REPORT UPDATE

Application No: BE/40/18/PL

Recommendation Report for Planning Permission

PROPOSAL: New access from New Barn Lane to Land West of New Barn Lane & relocation of 5 No. existing parking spaces.

Proposed Access to New Barn Lane

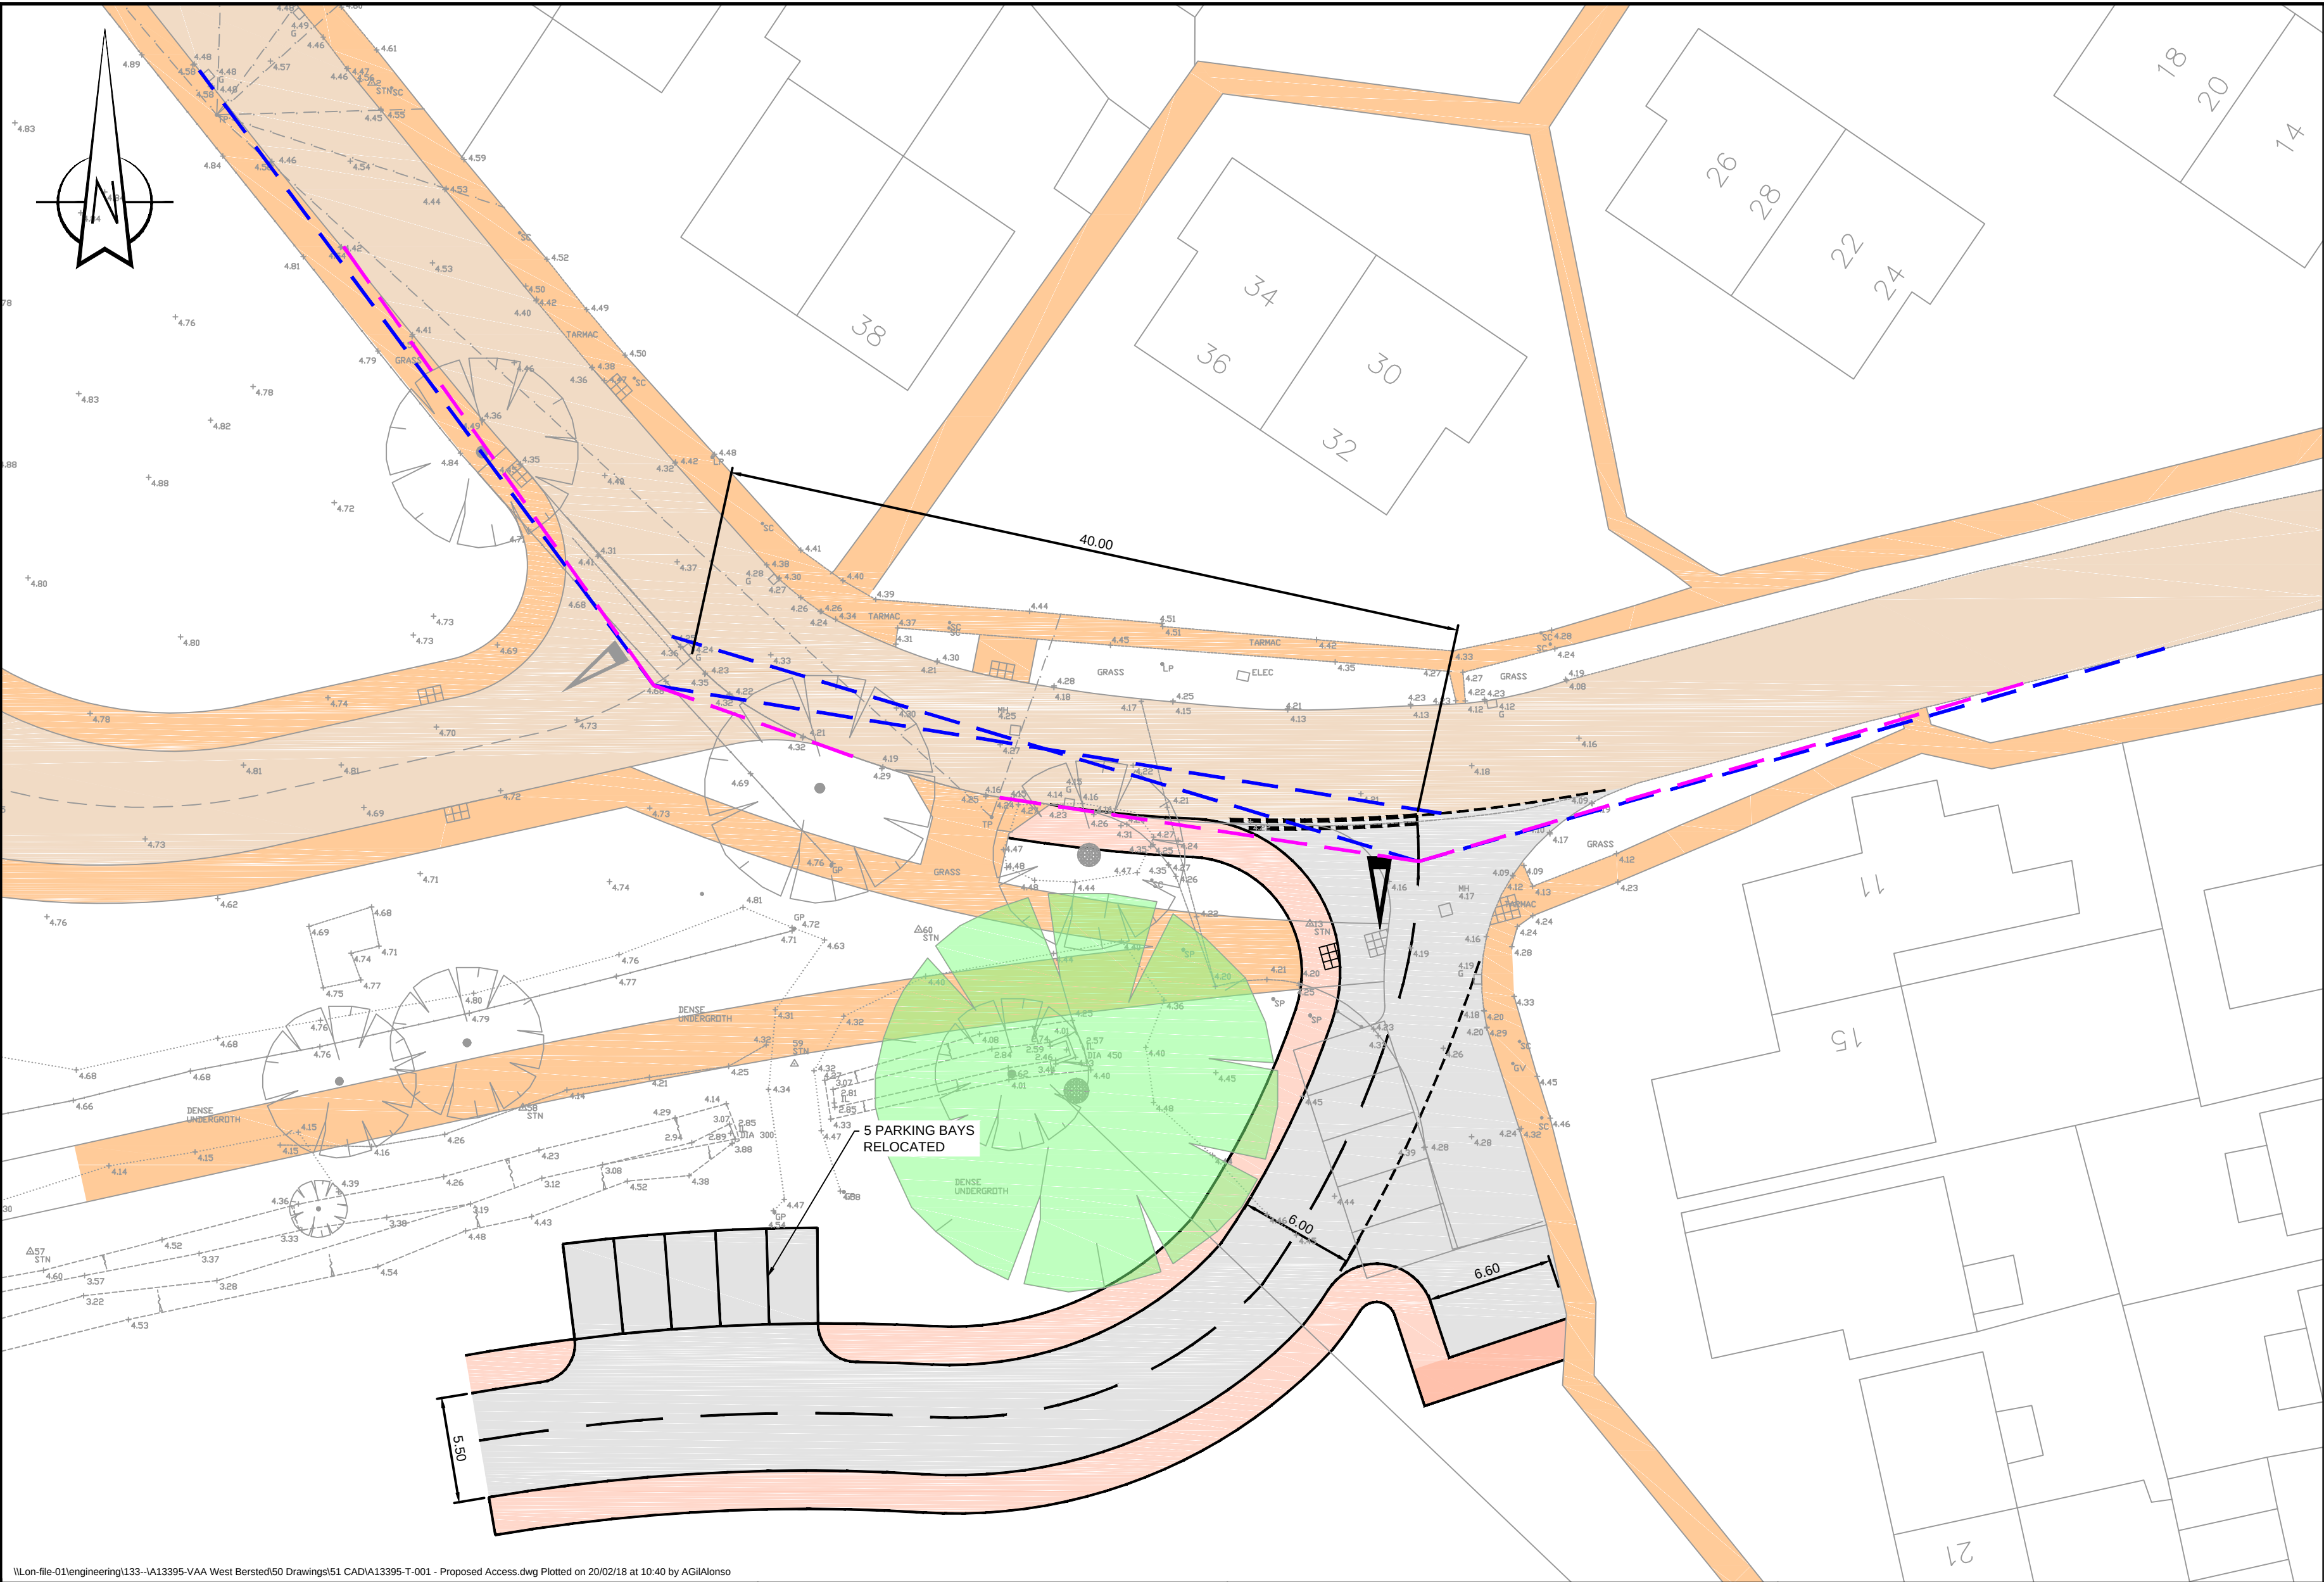
The Highway Authority have no objections to the proposed access arrangements but would look for a suitably worded condition to be included on any consent which requires the construction of the proposed access, as set out within the Pell Frischmann drawing entitled 'Proposed Access to New Barn Lane, drawing no. A13395-T-001, to be implemented prior to the occupation of any of the residential units it serves (associated with planning consent BE/77/16/OUT). The applicant should also be advised that they need to apply for the necessary post planning highway consent under section 278 of the Highways Act 1980.

The proposed access will be in the form of a priority T-junction with a carriageway width of 5.5m and footways located on both sides of the road. The existing vehicular access points associated with 11, 15 and 17 New Barn Lane are to be retained in their current locations.

The proposed access has been considered by WSCC Highways and no objection has been raised in relation to the proposed access. It was identified within their consultation response that visibility splays in accordance with recorded vehicle speeds for the road were demonstrated in accordance with guidance contained within the Manual for Streets.

- 4 With the exception of enabling works the development approved under reference BE/77/16/OUT shall not be commenced until such time as vehicular access to the site has been provided in accordance with the details specified on drawing no. 'A13395-T-001'.

- 5 The use of the new access shall not commence until visibility splays of 2.4 metres by 43 metres have been provided at the proposed vehicular site access onto New Barn Lane in accordance with the approved planning drawings. Once provided the splays shall thereafter be maintained and kept free of all obstructions over a height of 0.6 metres above adjoining carriageway level or as otherwise agreed.

Proposed Access Plan Statement

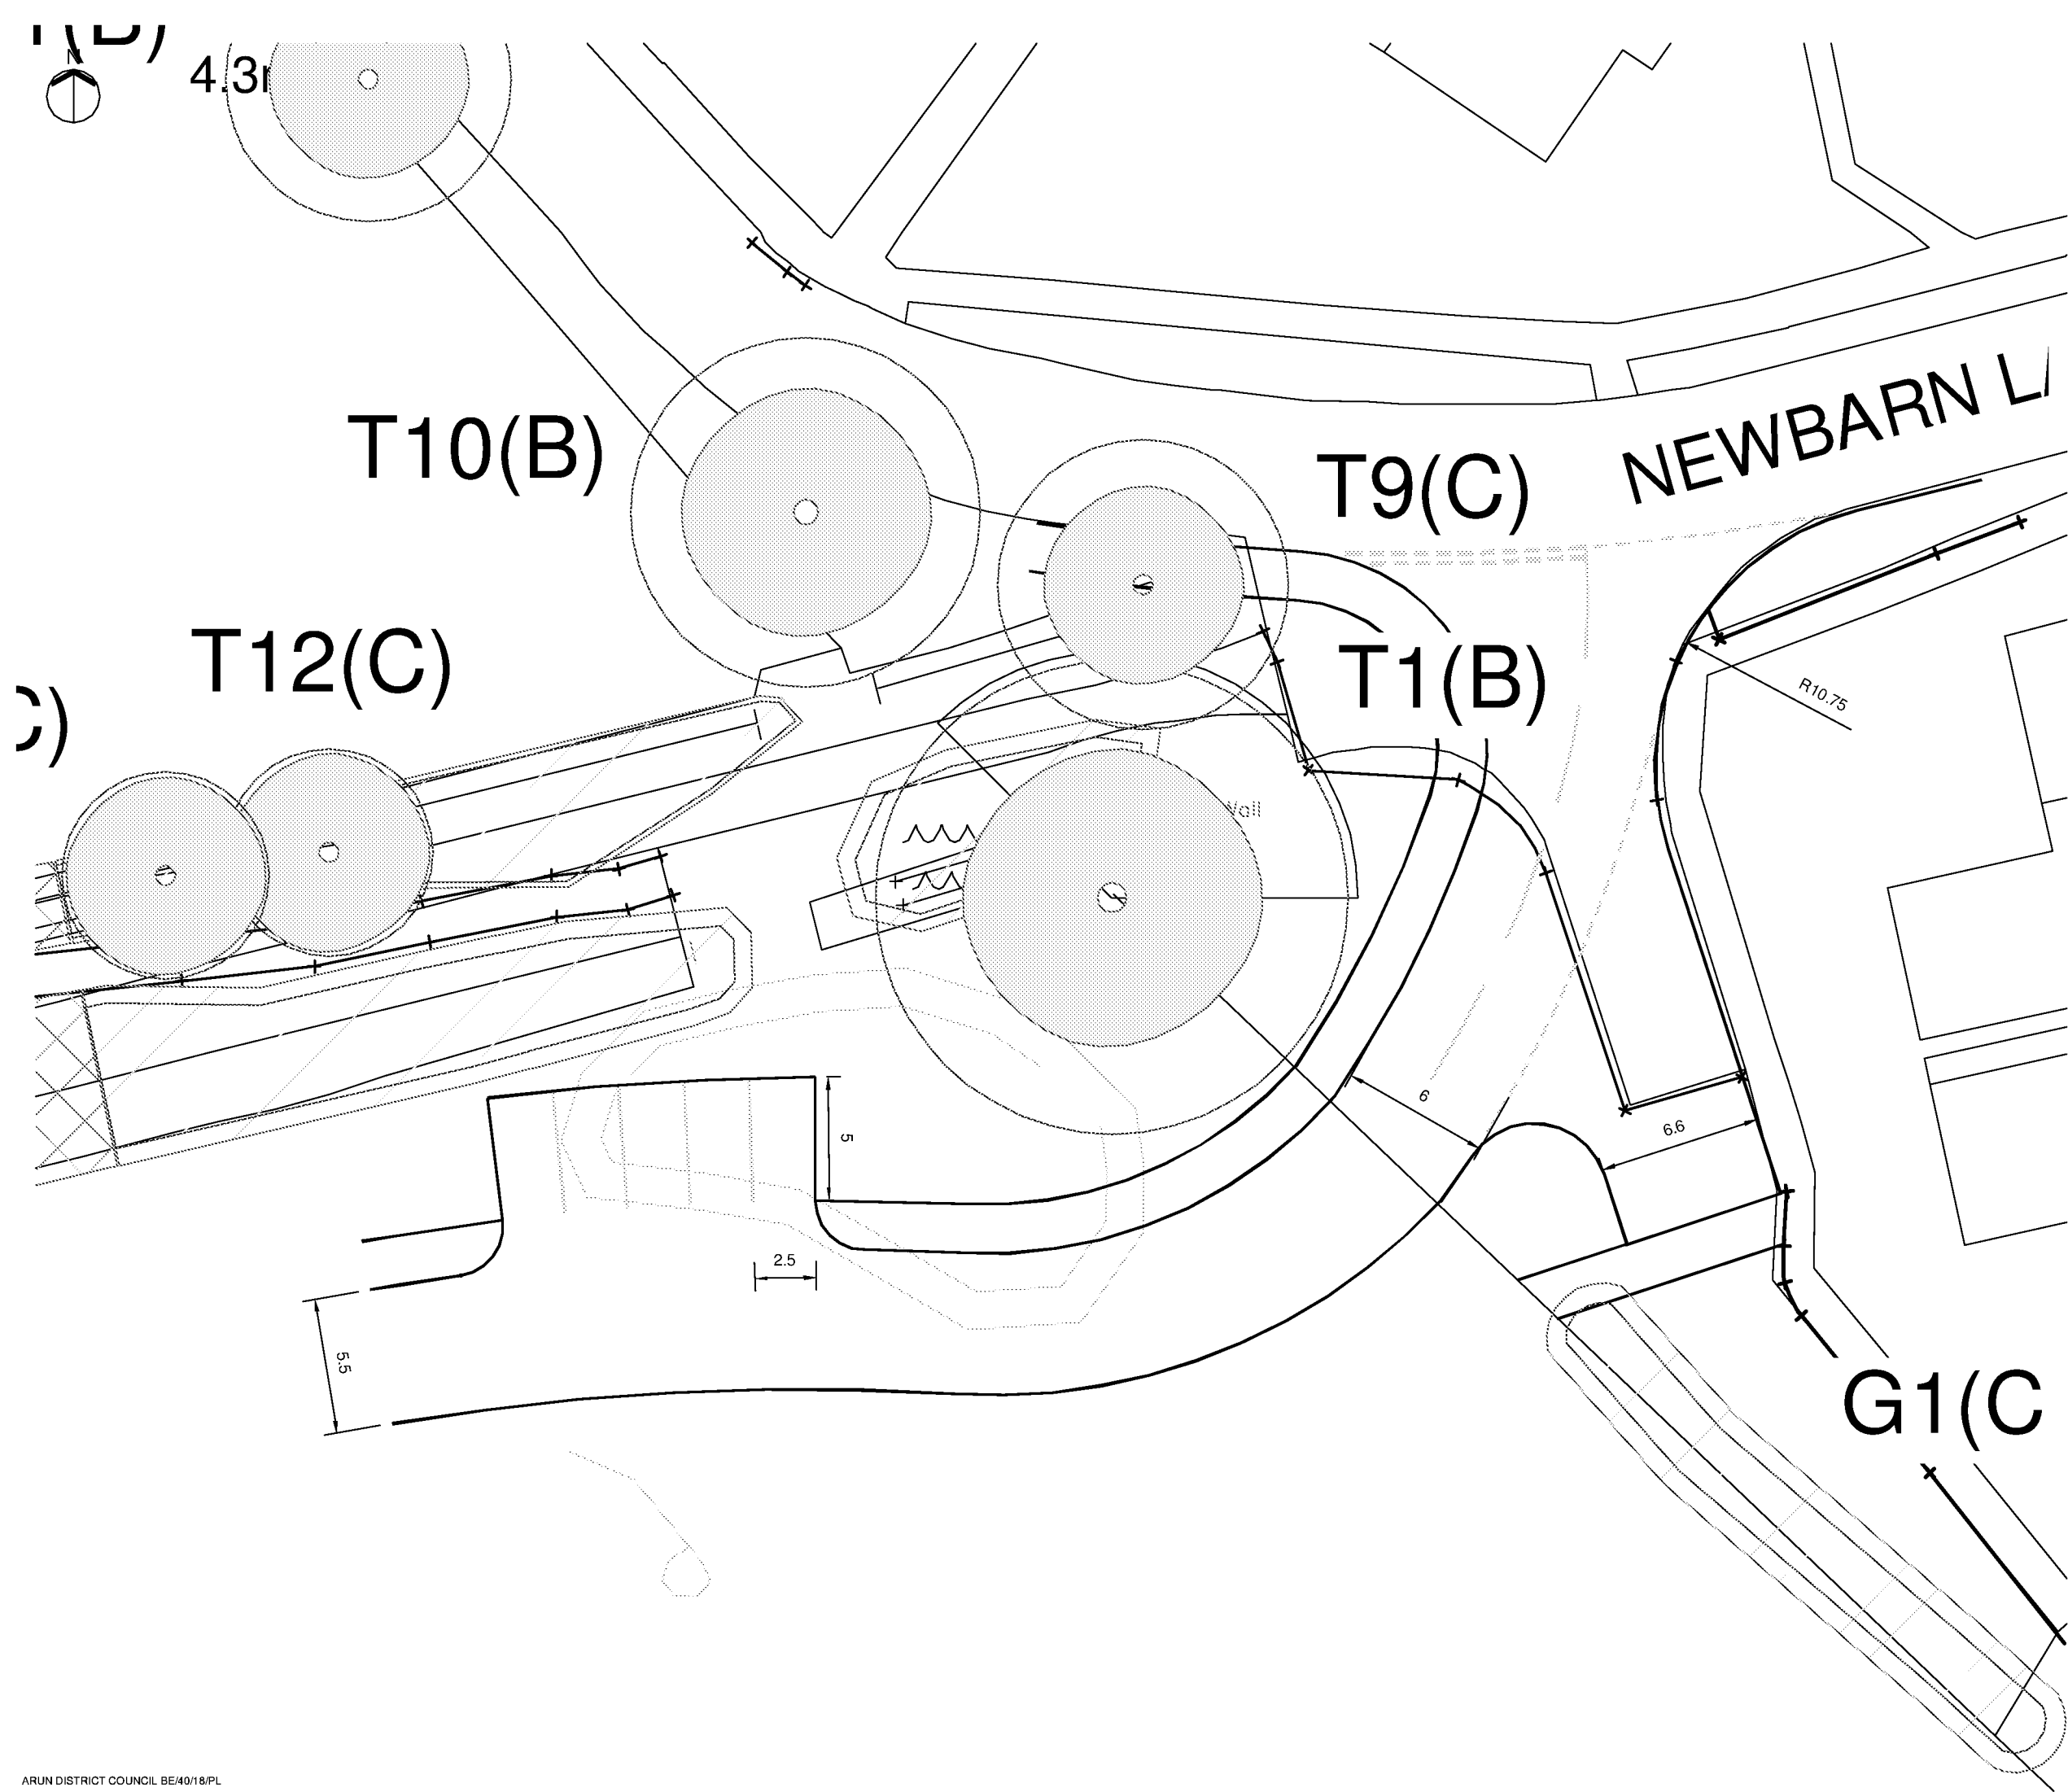
1. Please see amended for Condition 4 on the amended recommendation sheet.
2. Please see below summary of the consultation response from the Council's Tree Officer;
 - A degree of RPA incursion on the south-east aspect is proposed, not exceeding 1m intrusion and this is acceptable. This will be accurately marked out at the time of our joint pre-commencement site meeting and define part of the Construction Exclusion Zone (CEZ).
 - The applicant will now need to ask their appointed Arboriculturist to submit a Tree Protection Plan that adequately protects the remaining RPA of T1-Oak throughout the duration of any development.
 - Facilitation pruning will be necessary, involving the careful reduction back of branches to achieve installation of tree protective fencing at the correct position.
3. Please see Conditions 8, 9 and 10 on the amended recommendation sheet.

- 8 Prior to the commencement of development, a Tree Protection Plan (TPP) shall be submitted to and approved in writing by the Local Planning Authority. Development shall be carried out in accordance with the approved details. The TPP shall include details of the specification and location of tree and hedgerow protection by a fence in accordance with BS5837 (2012).

· A pre-commencement site meeting is to take place between the Arun DC Tree Officer and the Arboricultural Expert representing the site owners - at this meeting protective fencing will be inspected - this will be assessed to verify it is 'Fit for Purpose' as required under British Standard 5837 (2012) and has been erected and positioned exactly as shown on the Tree Protection Plan (as required by condition 8).
